POST RESPONSE TO SUBMISSIONS REPORT

ALEX AVENUE PUBLIC SCHOOL_SSD_9368

This supplementary Response to Submissions (RtS) Report has been prepared to respond to further submissions received in relation to SSD 19_9368 for 'Alex Avenue Public School'.

OPTION 1: NO OSD REQUIRED ON SITE

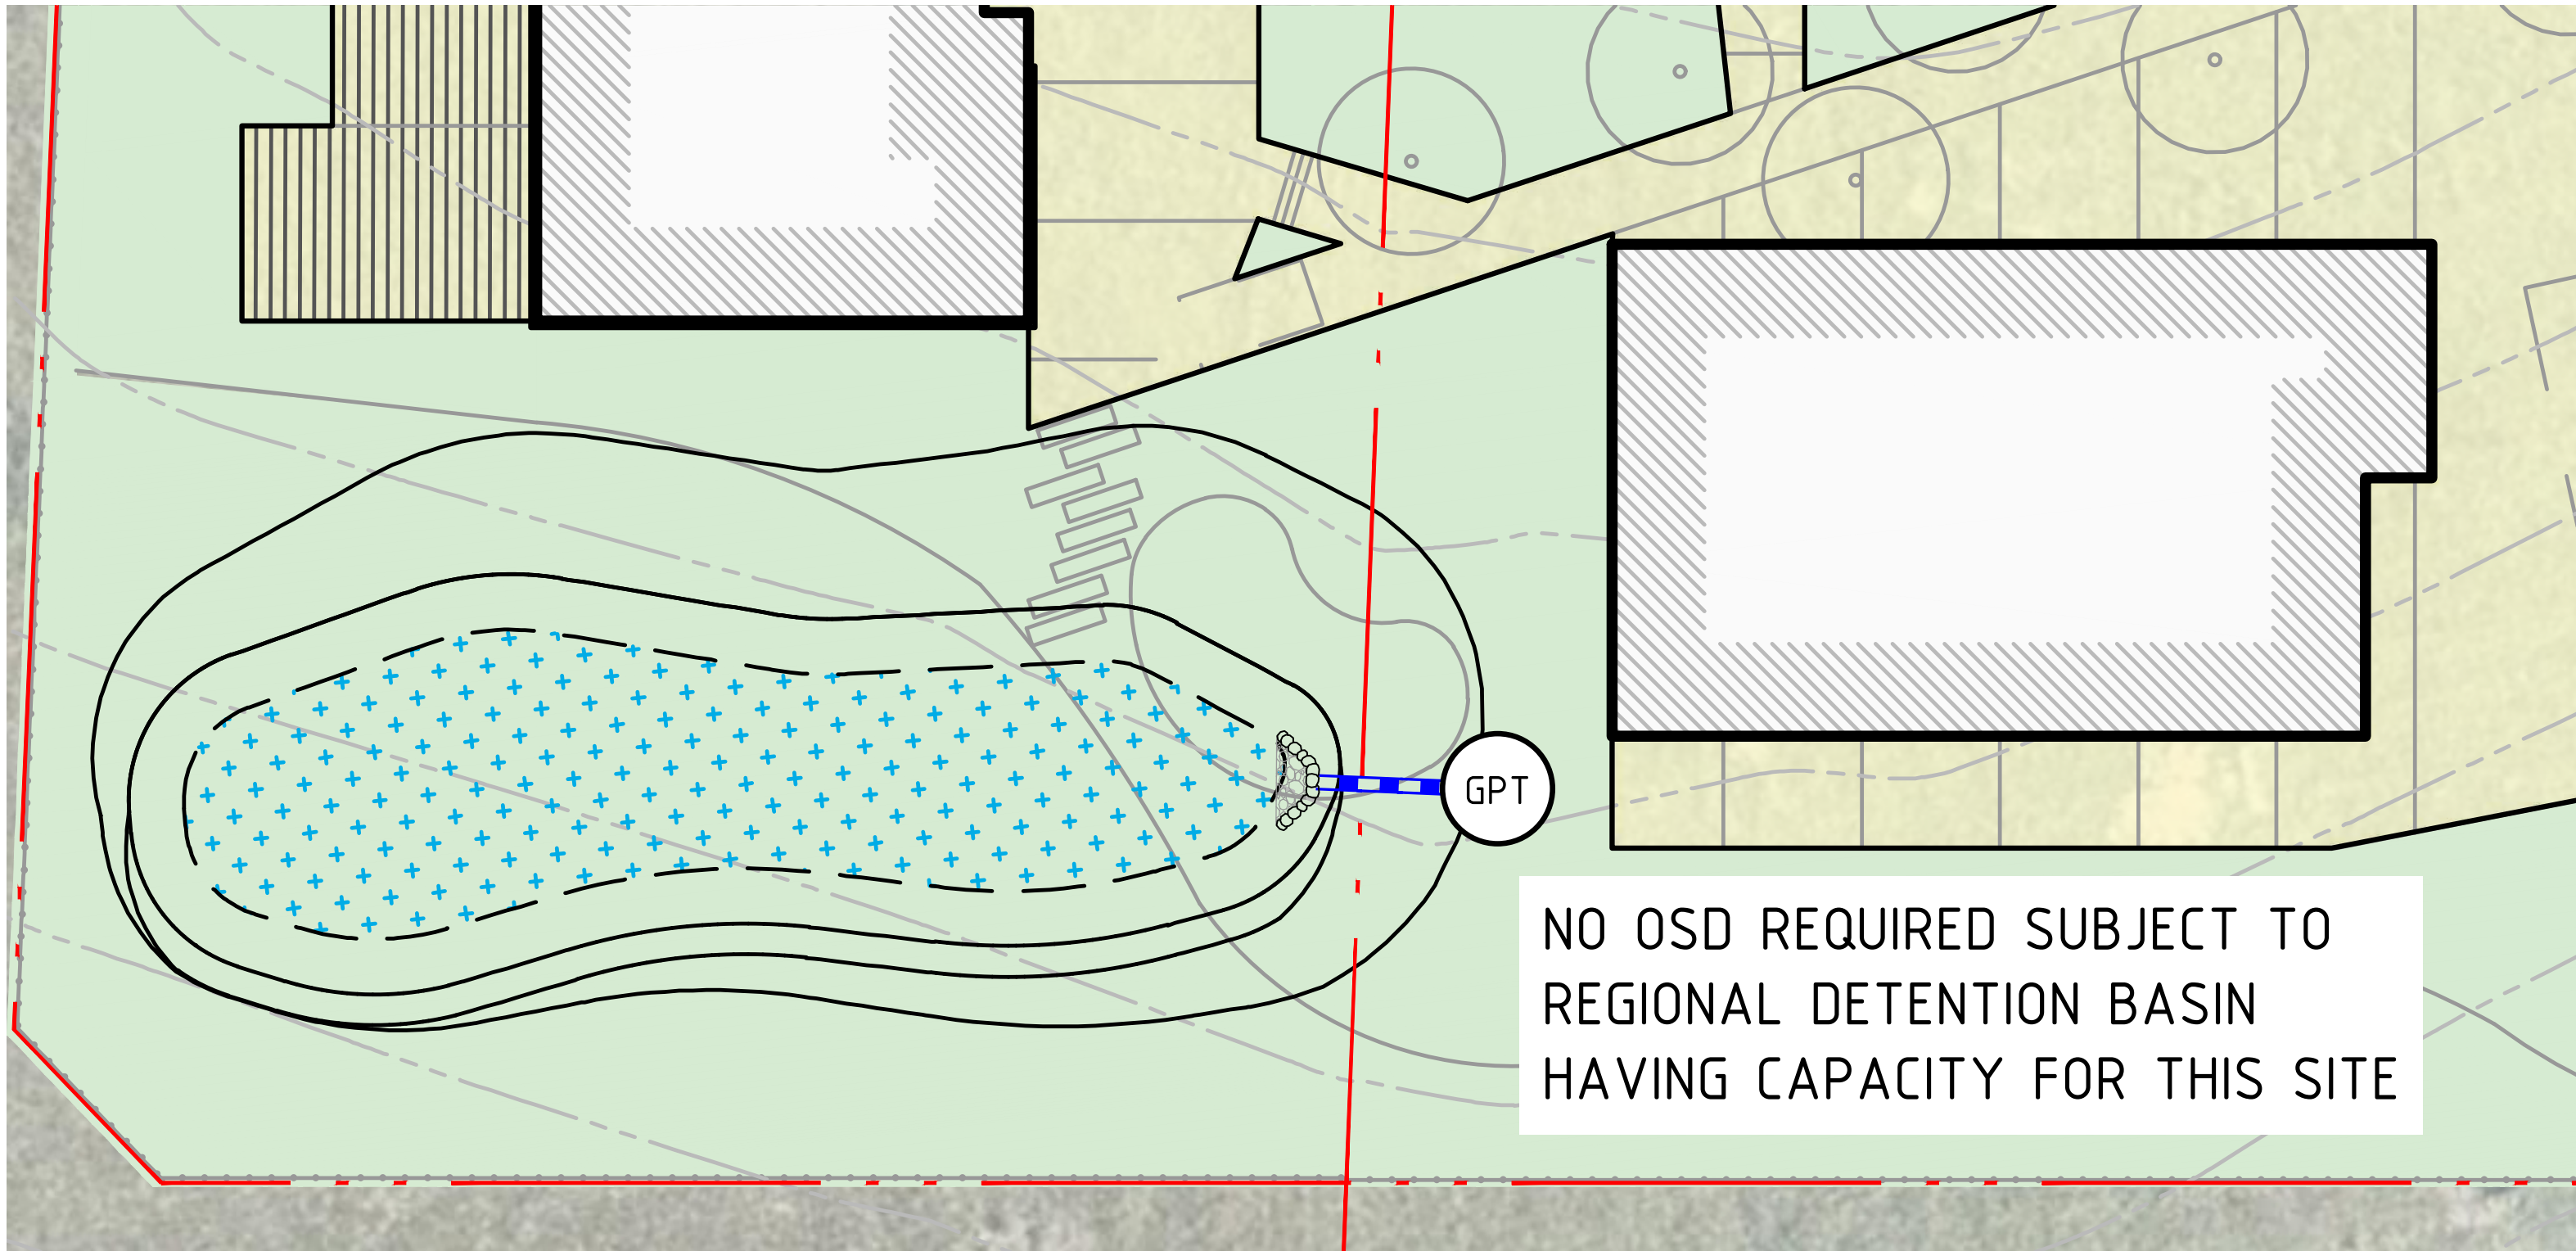
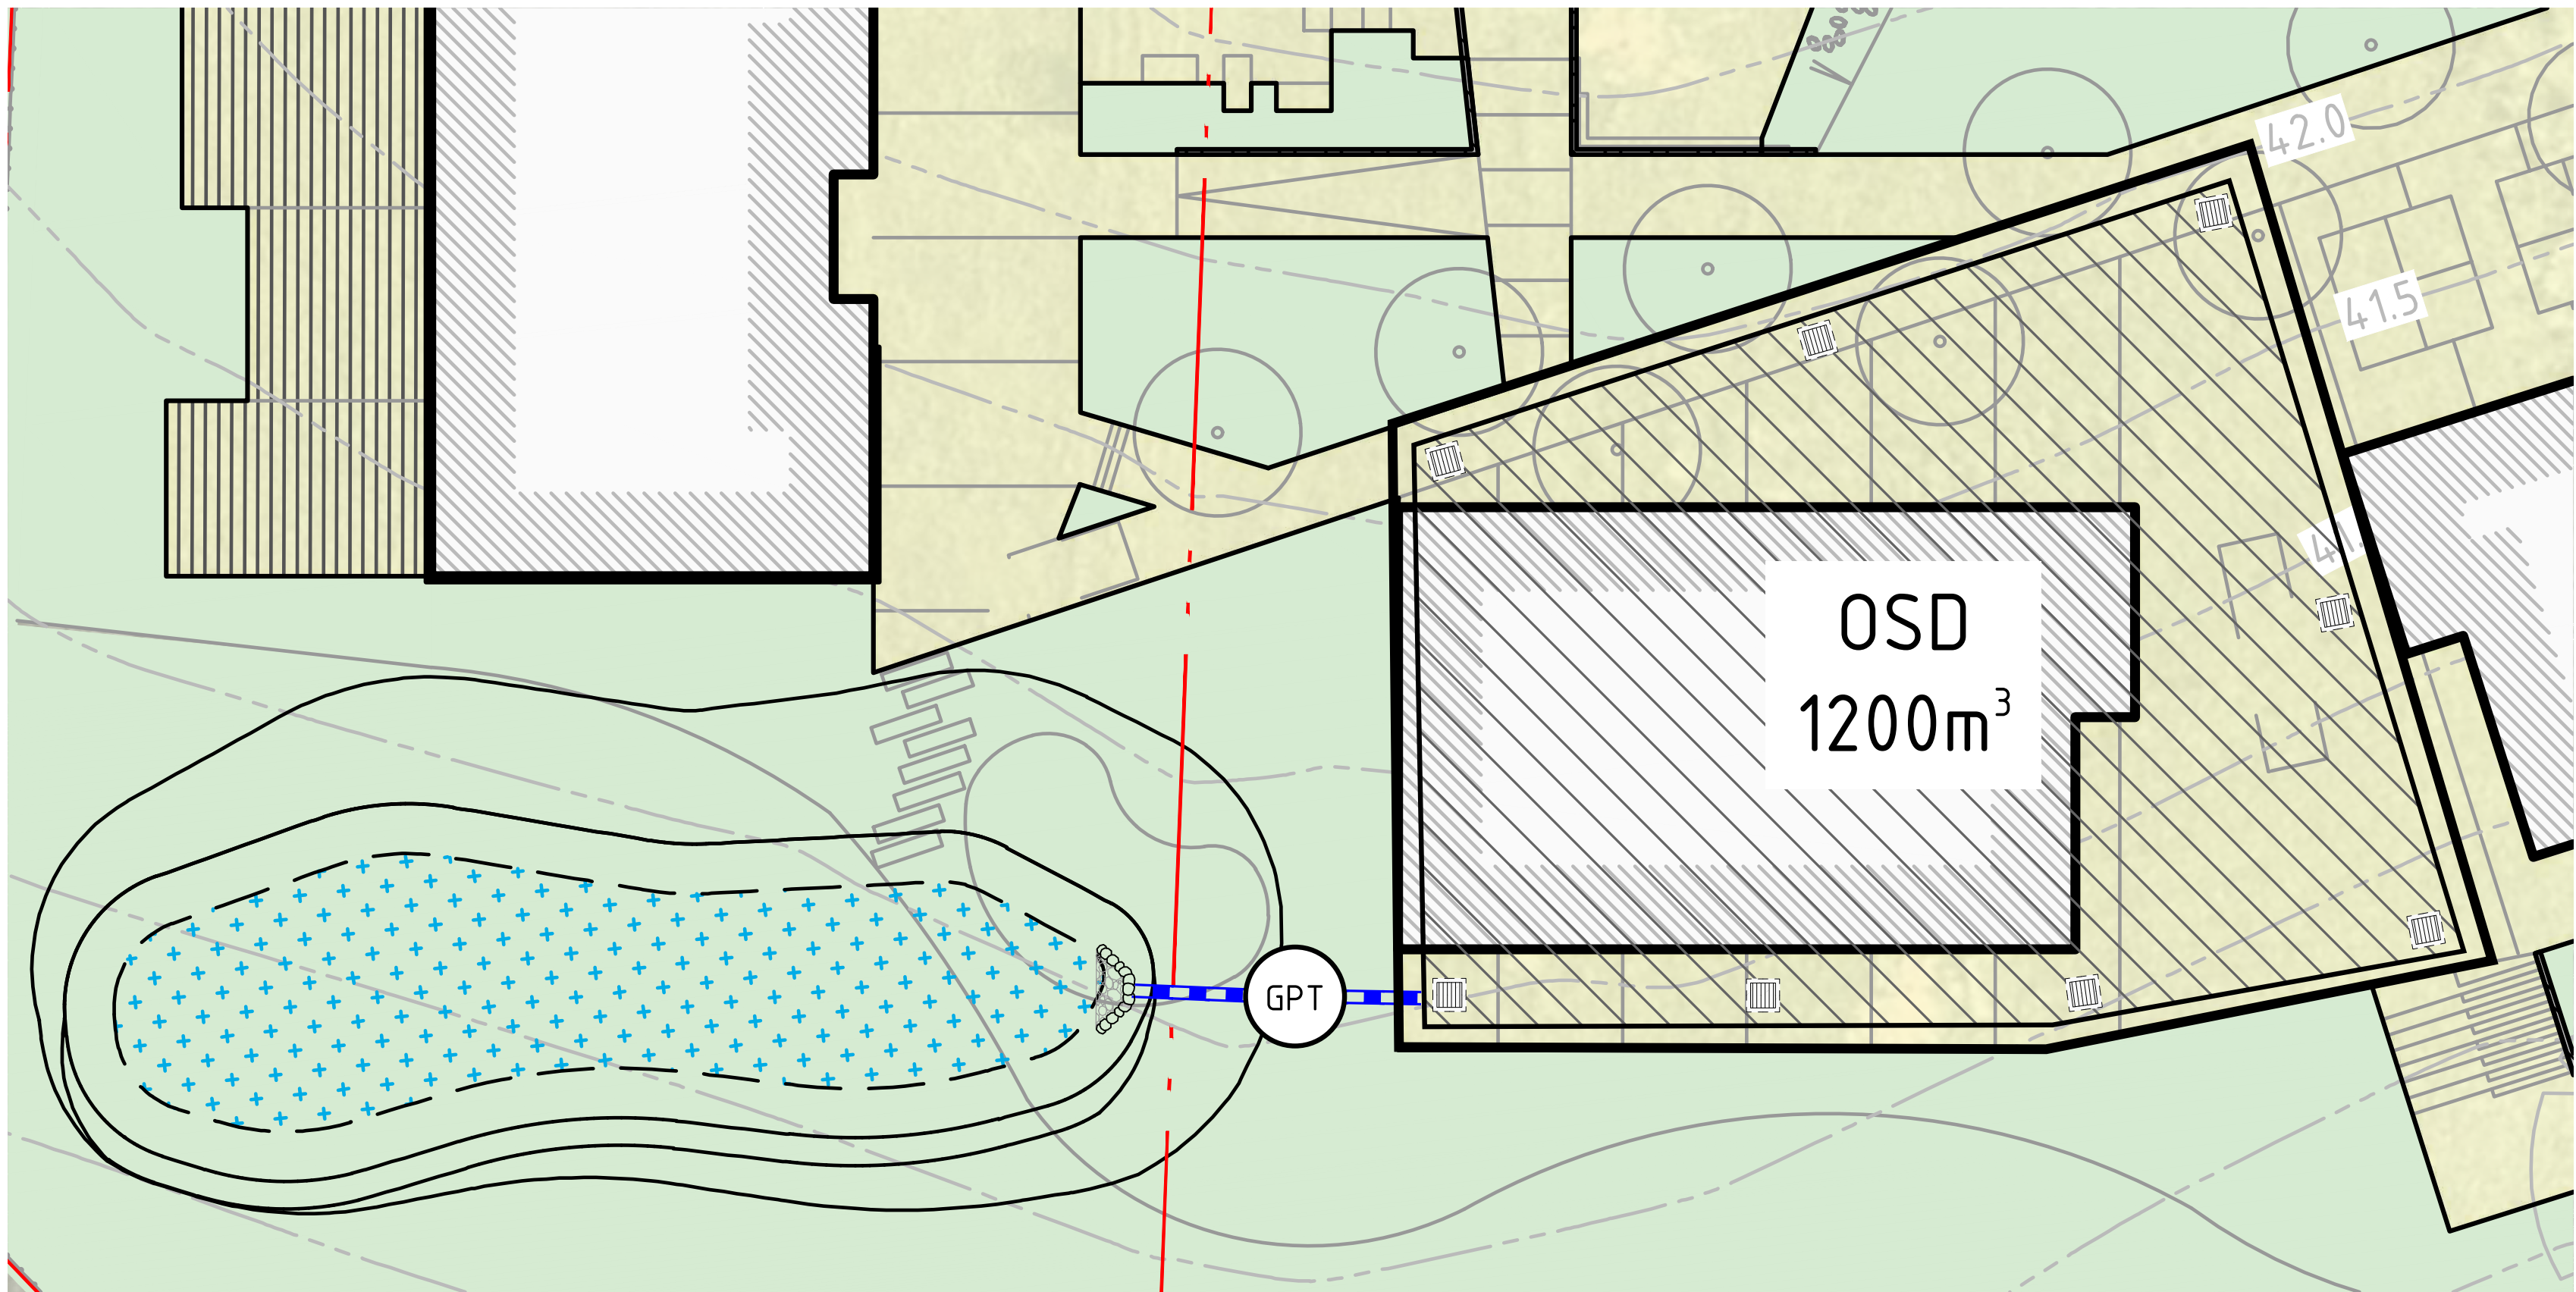
19. Site Discharge	The applicant has chosen to provide a bio retention swale in the south west corner of the site and discharge concentrated flows from the site by overland flow in south west corner of the site. This is not supported by Council. The development either permanent or temporary on-site detention system.	Permanent onsite detention is to be provided in accordance with BCC policy. A condition of consent can be imposed requiring permanent OSD.
